MECKLENBURG COUNTY  
Park and Recreation Department

MEMORANDUM

**DATE:** October 25, 2023

**RE:** Rezoning Petition #2023-069  
PID# 19312102

**RZP-2023-069
 REZONING**

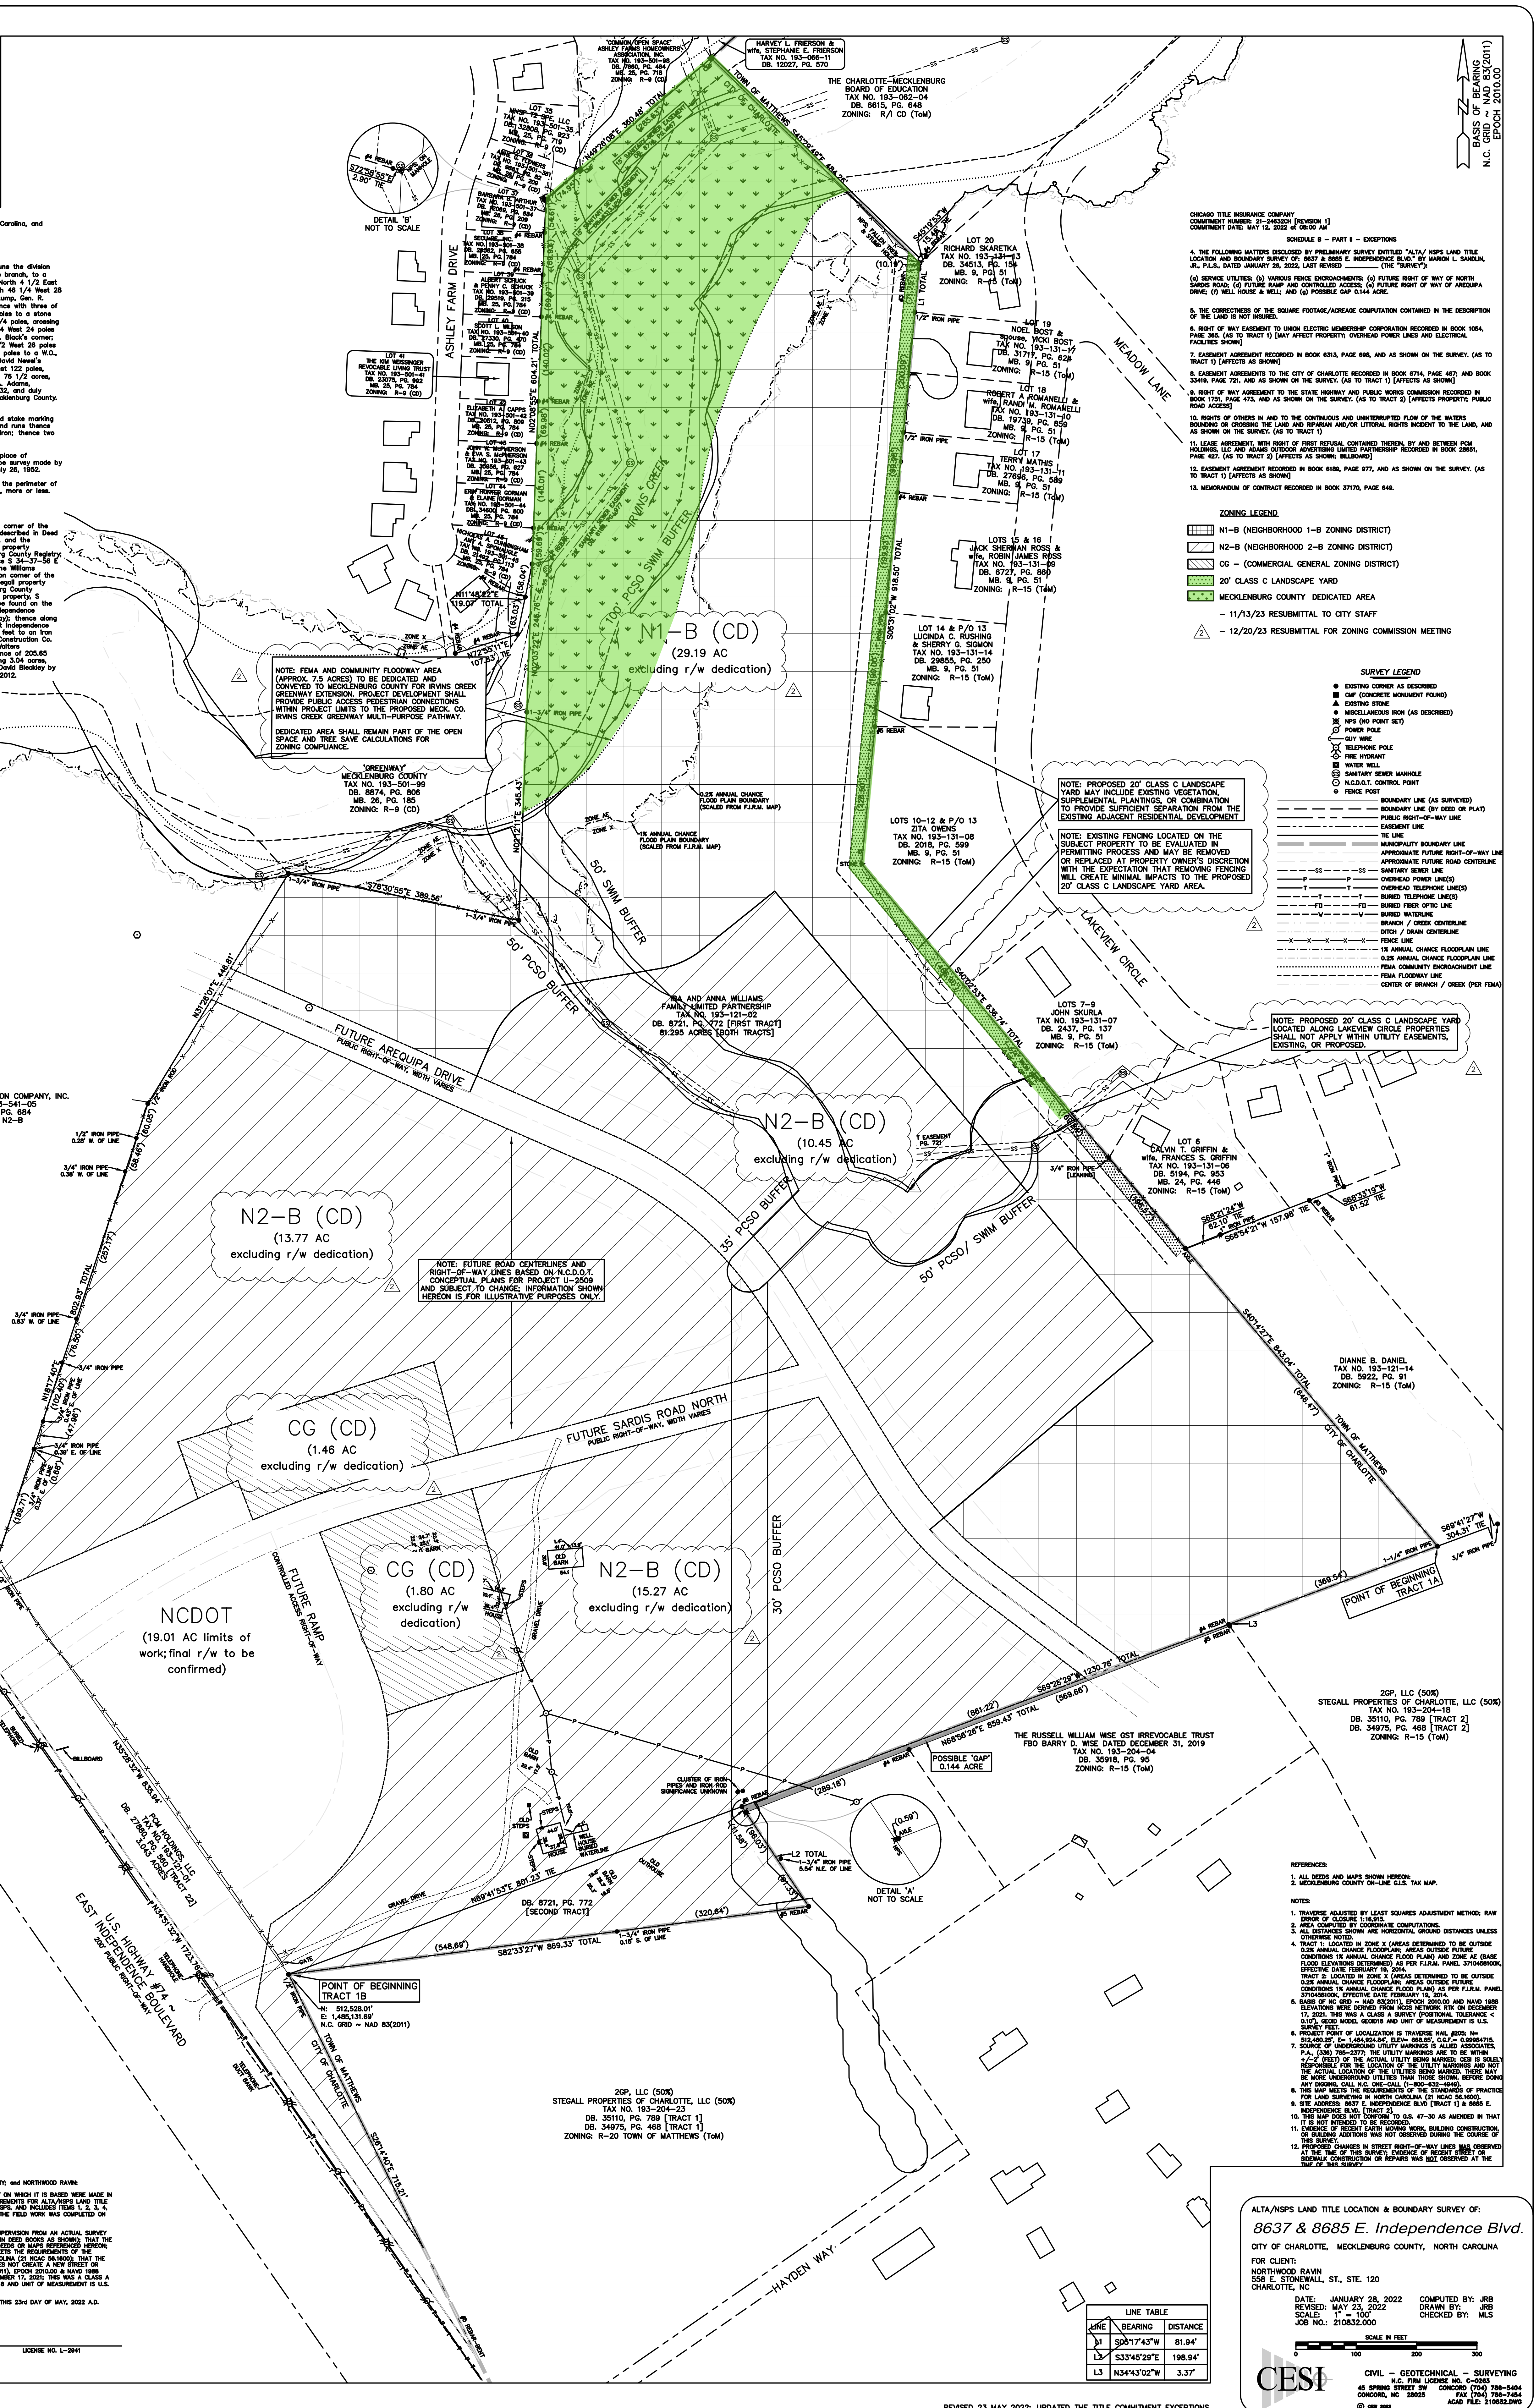
The dedication note should read: "to be dedicated and conveyed to Mecklenburg County for Irvins Creek Greenway..."

MCPR requests a minimum 100' width permanent greenway access easement to Mecklenburg County in order to construct an accessible trail connection between Irvins Creek Greenway and the development's public street ROW. Greenway easements may overlap tree-save.

MCPR requests minimum of 3.5 acres to be dedicated and conveyed to Mecklenburg County for a future local park. This requested park land shall be adjacent to a public right-of-way for access and is conducive for the development of the typical amenities found in a local park and cannot include tree save parcels or stormwater BMP's. Ideally, the proposed park land shall be adjacent to the requested greenway access easement.
